East Anglia ONE North and East Anglia TWO Offshore Windfarms

Applicants' Comments on Suffolk County Council's Deadline 7 Submissions

Document Reference: ExA.AS-20.D8.V1

Date: 25th March 2021

TYPICAL INFILTRATION BASIN CROSS SECTION

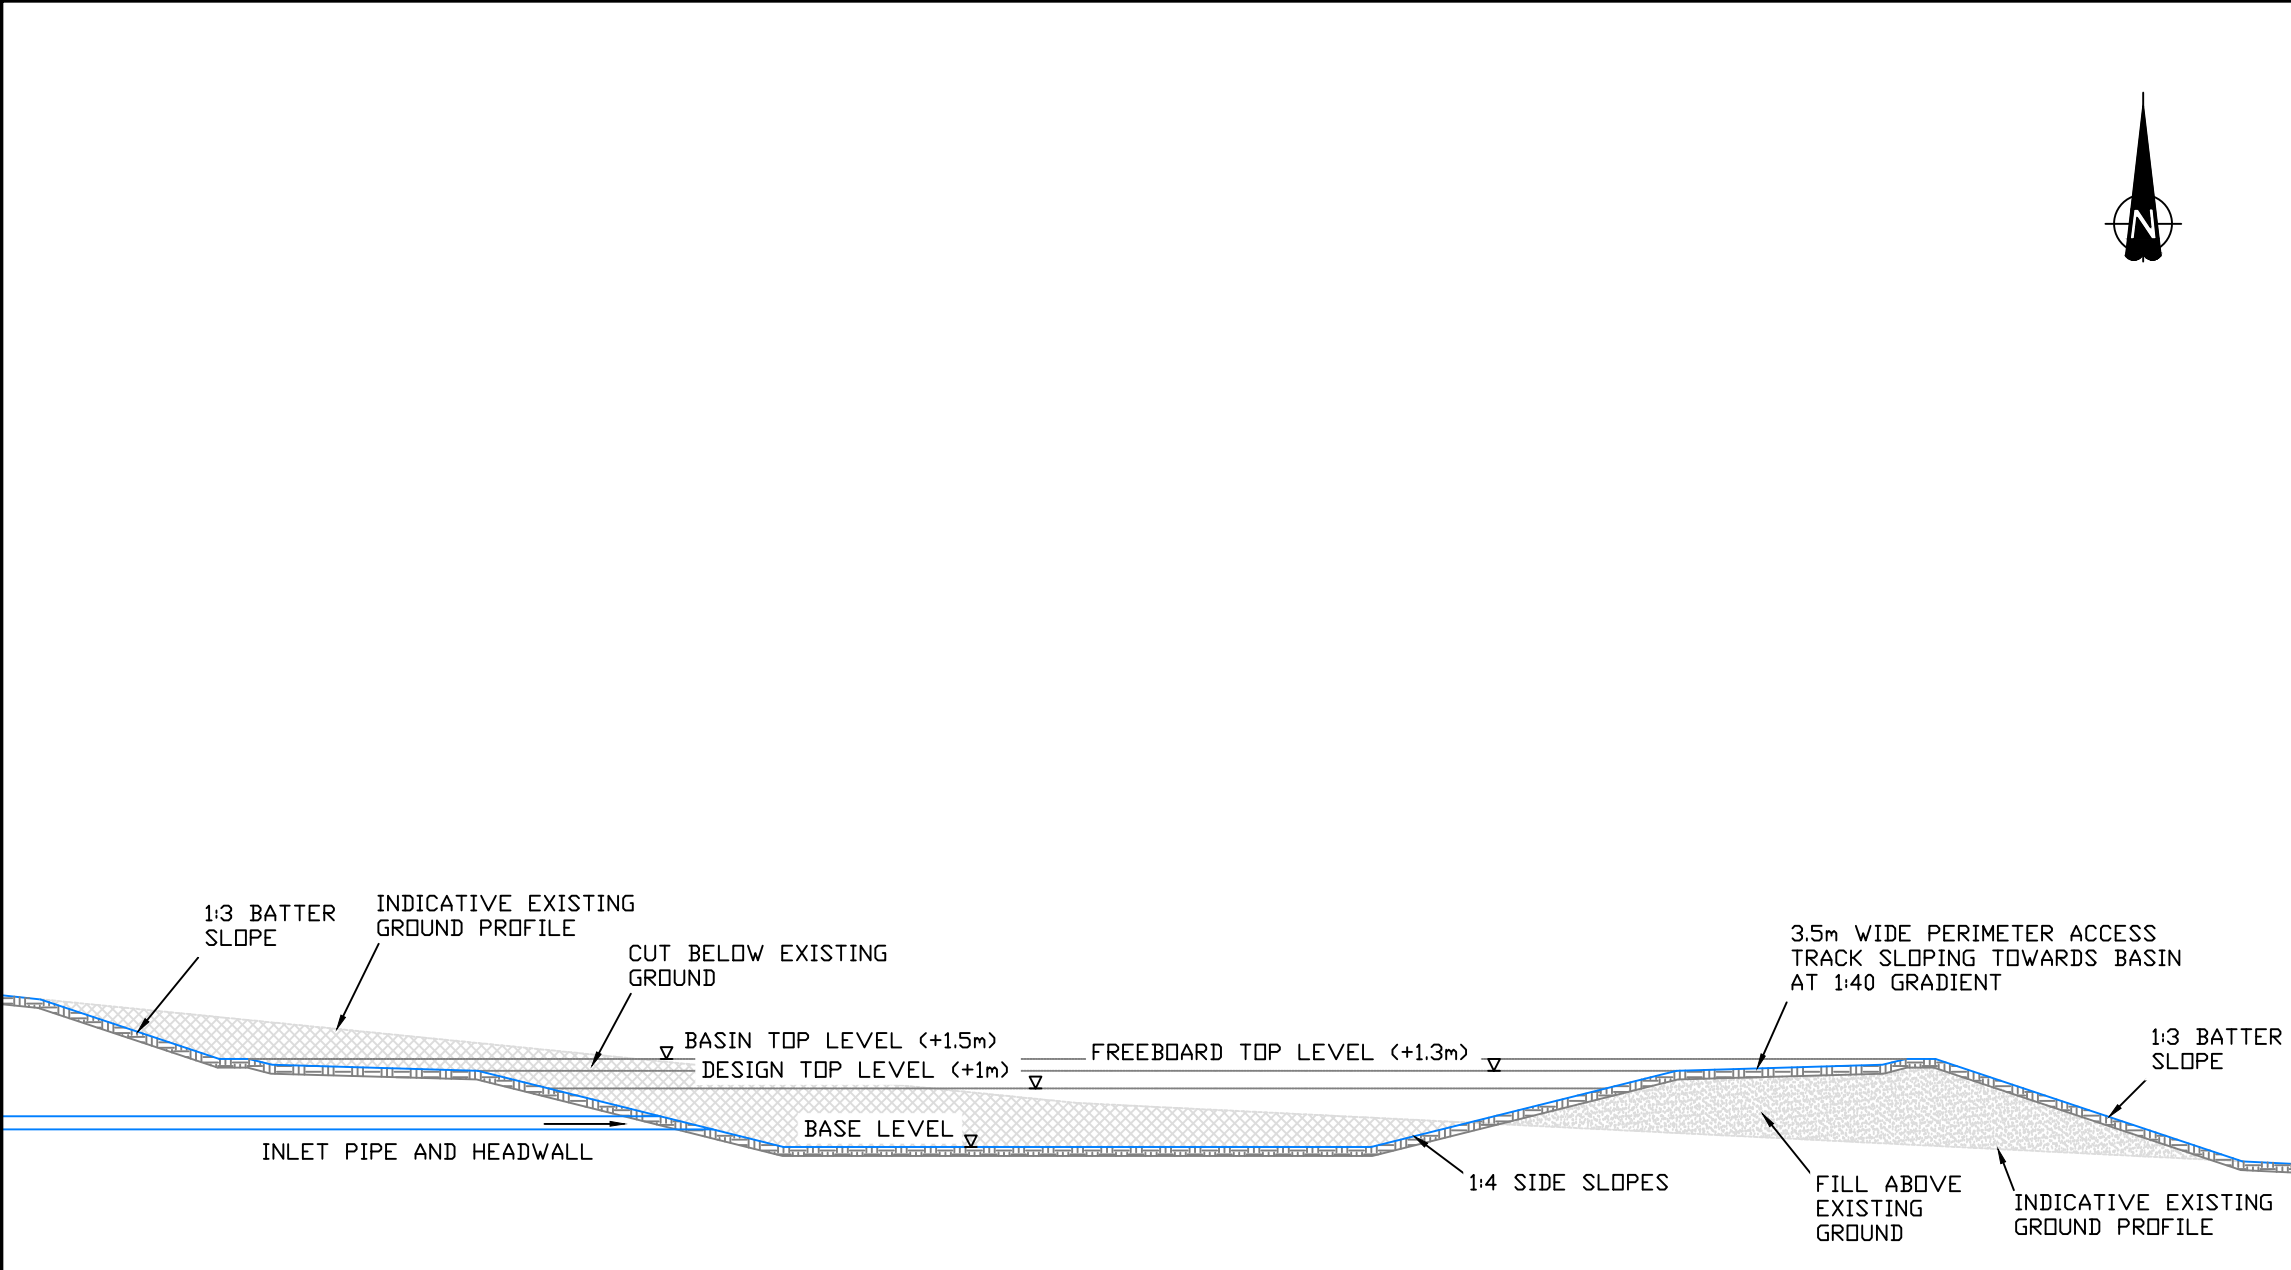
ID	SPR Statement	SCC Comment	Applicants' Comments
		<p>0.7m with design freeboard + 0.3m (1.0m deep). These two statements are contradictory, which has been used for the calculations? 1 in 100 + CC + 1 in 10 + CC water depths for each basin, based on calculations are; SPR substation = 0.858m NG substation = 0.99m This complies with national and local guidance and best practice. This does not match the water depths annotated on the drawing in Appendix 3, SCC assume these need to be corrected to mirror the calculations provided?</p>	<p>the rain events modelled. These parameters were chosen to maximise infiltration rates and therefore reduce the half drain times. This additional volume is also beneficial to have as a further buffer. The basin size could technically be reduced, but that would lead to a longer half drain time.</p> <p>As stated above, the drawings and figures provided within the OODMP at Deadline 6 (REP6-016) are <u>indicative</u> and for demonstration purposes only. The final sizes and depths of the basins will be confirmed during detailed design.</p>
